RE: Comment Response for Front Range-Midway Solar Project, LLC Application for a Wind/Solar Energy Generation Overlay (WSEO), Submittal #1,

Front Range-Midway Solar Project, LLC (Project Company) is pleased to submit the revised sections of the Front Range-Midway Solar Project (Project) application for a Wind/Solar Energy Generation Overlay (WSEO), submittal #1. The revisions to this application address the review comments provided by the El Paso County (EPC) Planning & Community Development on November 27, 2017. All comments provided in the letter and the Project's response or a reference to Project's response within the WSEO application are listed below.

Attachment 27 Photo Simulations

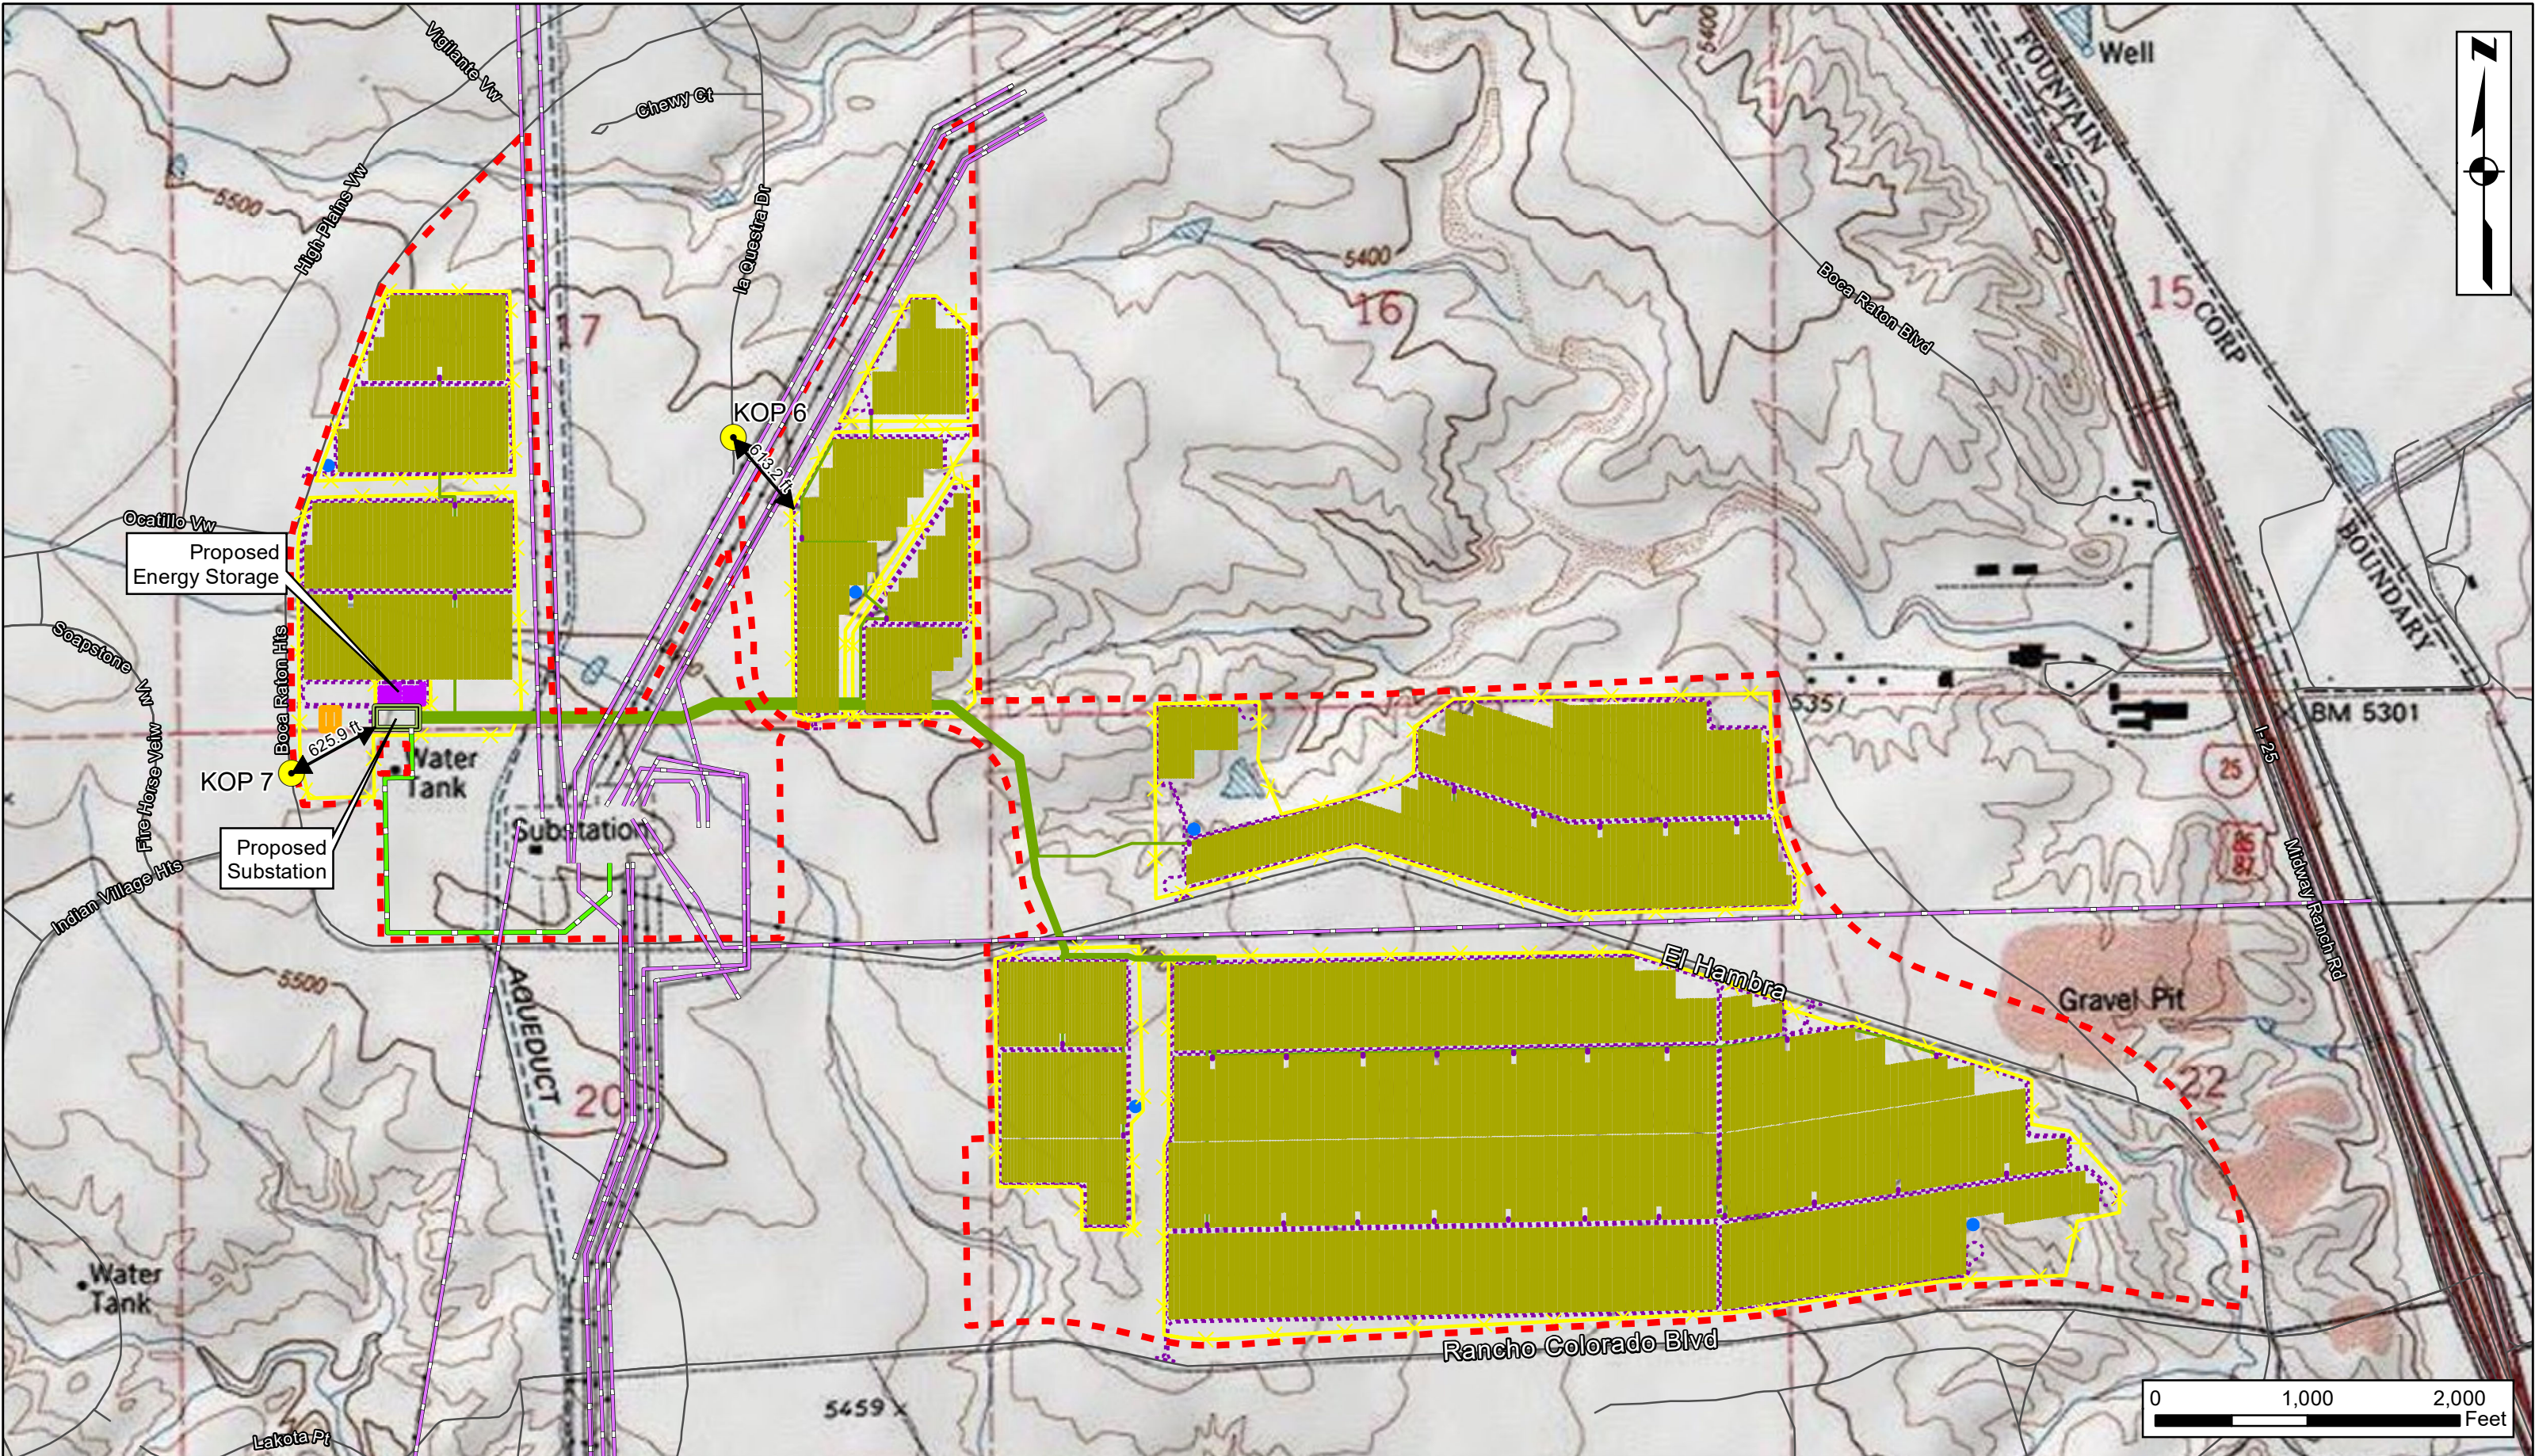
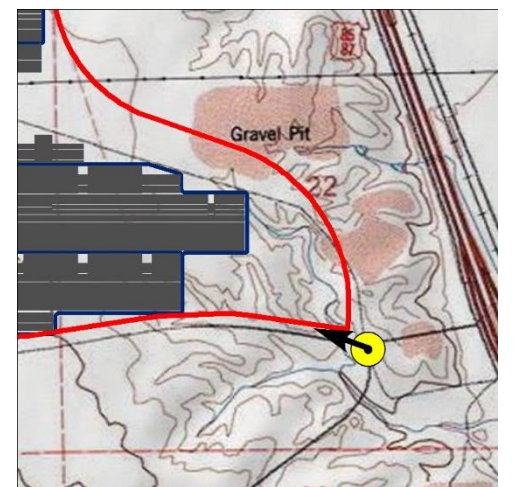
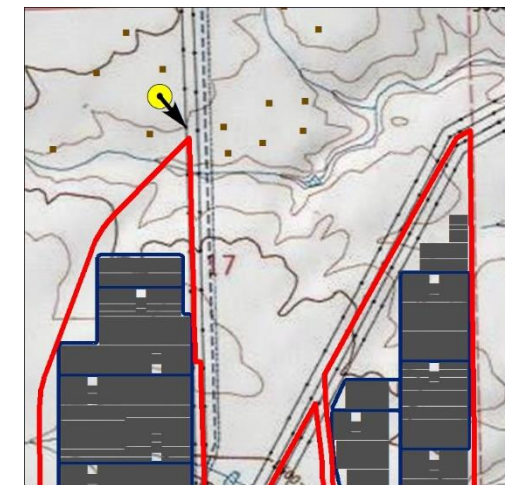
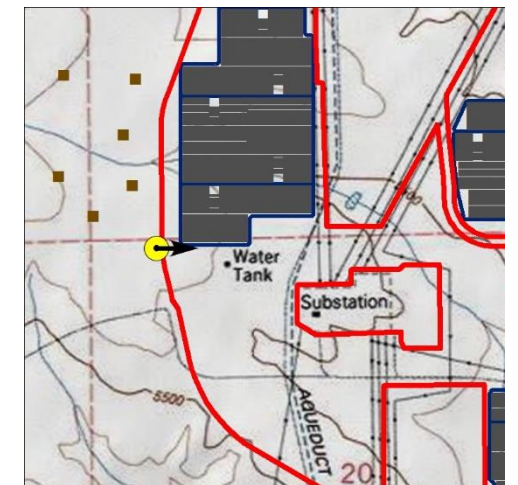
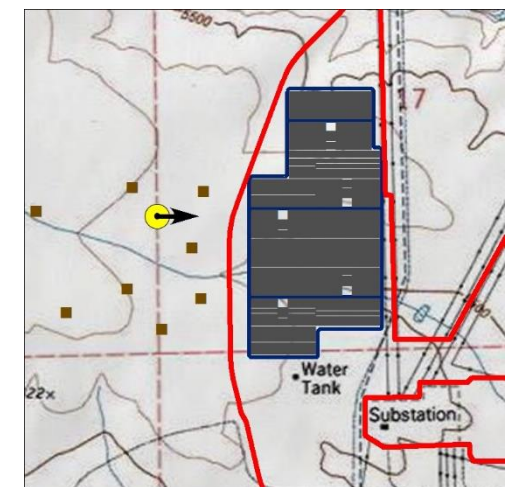
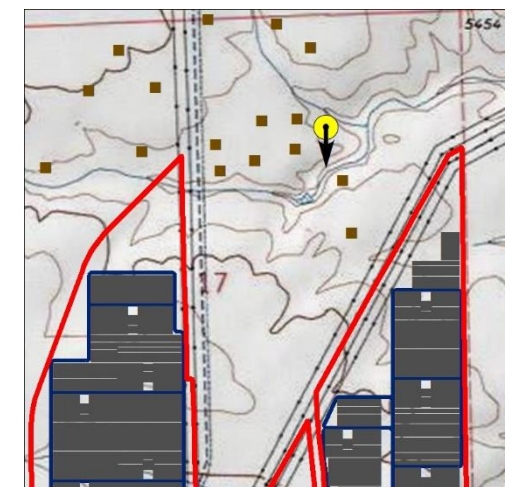
2. The visual impacts to adjacent properties are anticipated to be minimal based on the photo simulations provided except on the northwest and northern portions of the property. Please reach out to those neighbors (observation point 4). The lots on Moab and Van Whey Court are sandwiched by panels. An opaque fence may be appropriate to mitigate the impacts. Please contact the developer. Staff suggests applicant confirm there is no request for opaque fencing to

mitigate the visual impacts to the residential homes immediately across from the panels along Boca Raton Road. This is to prevent concerns at the hearing.

Response: The Project Company voluntarily held a community meeting at the Prairie Heights Elementary School on September 13, 2017. At least 26 members of the community were in attendance. Visual impacts were not identified as a concern during that meeting; however, the Project Company will hold an additional community meeting at the same location on January 31, 2018 at 5:30 p.m. to address potential landowner concerns. The EPC Planning and Community Development Department will be invited to the meeting and is encouraged to attend. To date, no request has been made to the applicant by adjacent neighbors or the adjacent residential project developer for opaque fencing to be installed at the Project site. The Project will coordinate with landowners to mitigate reasonable concerns identified.

Physical Constraints / Other Design Constraints Subject to Title Clearing / Preliminary Design

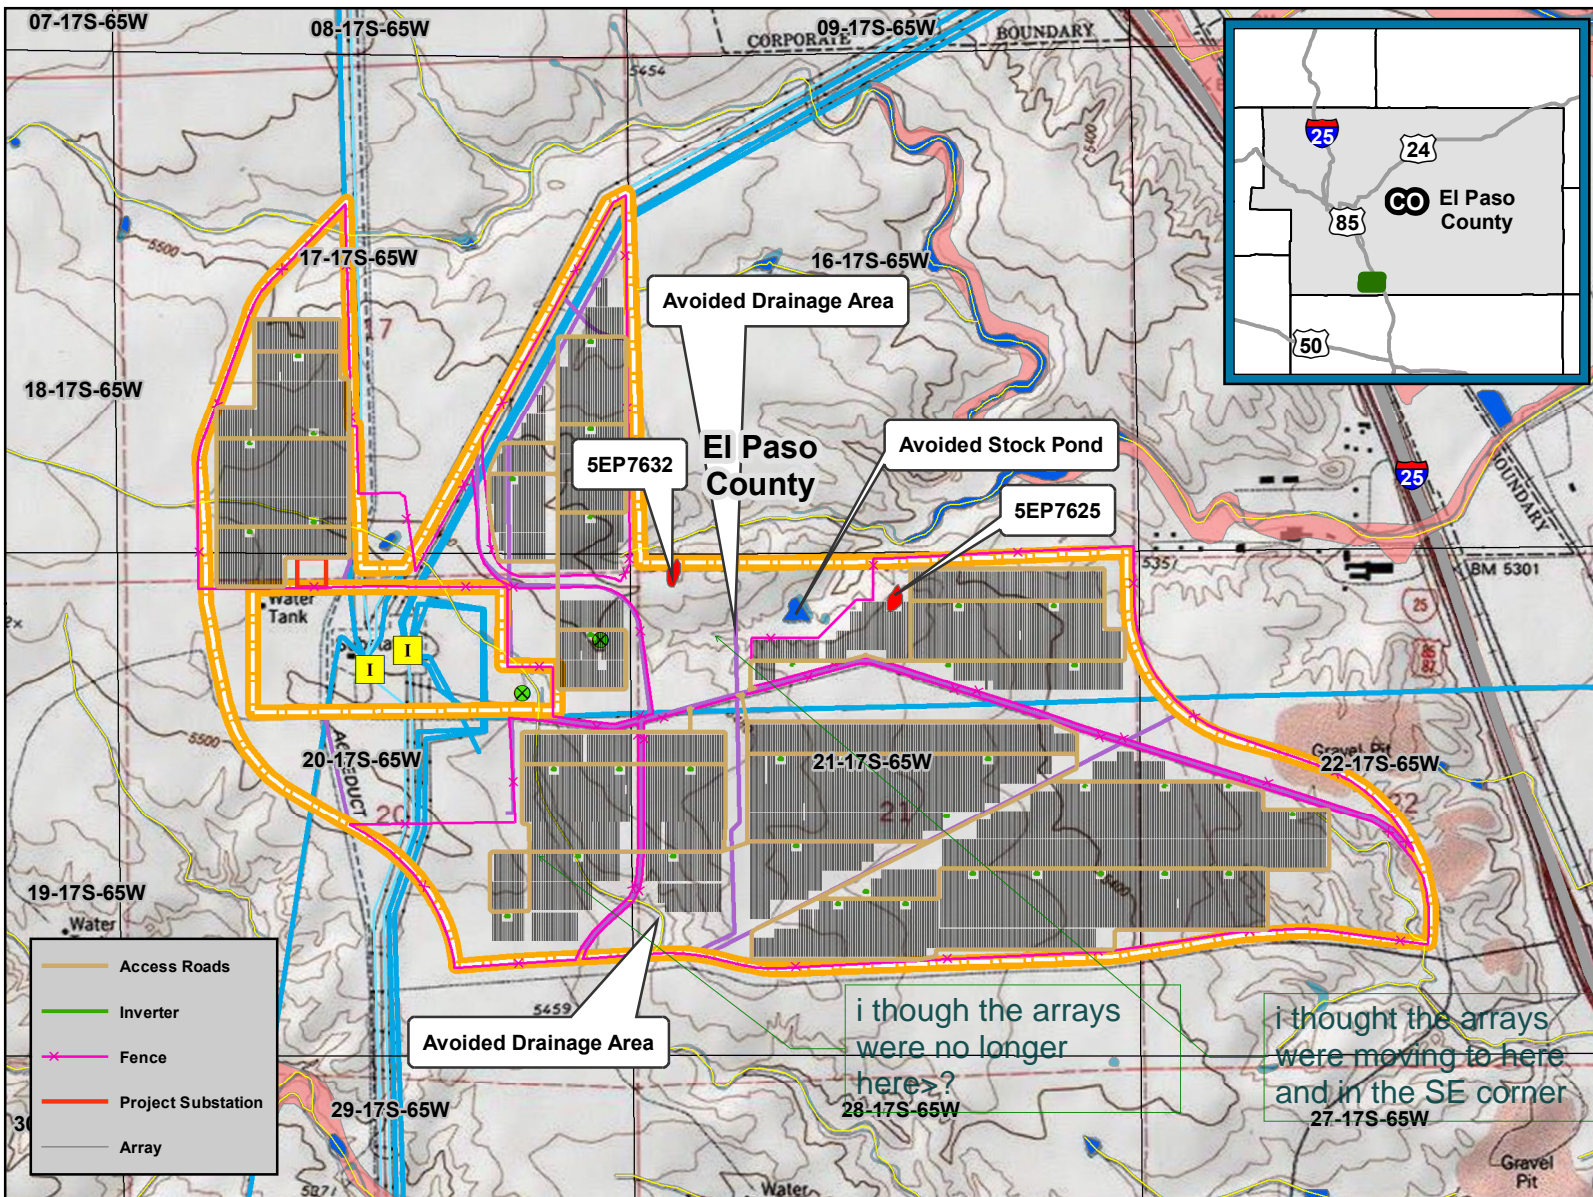
1. The geotechnical report prepared by Terracon should include a map identifying drainage ways, constraints and hazards to be avoided. A defined drainage channel runs through the site. Identify that the channel is not be impacted or if it, provide a reference to the drainage report.

Response: The applicant has prepared a Physical Constraints Map (Attachment T; Optional Documents) depicting drainage ways, constraints, and hazards to be avoided. This map depicts avoidance of the defined drainage in the north central and southern portion of the project, as well as stock pond.

Potential archaeological sites to be avoided are also depicted and shown as avoided on the Physical Constraints Map.
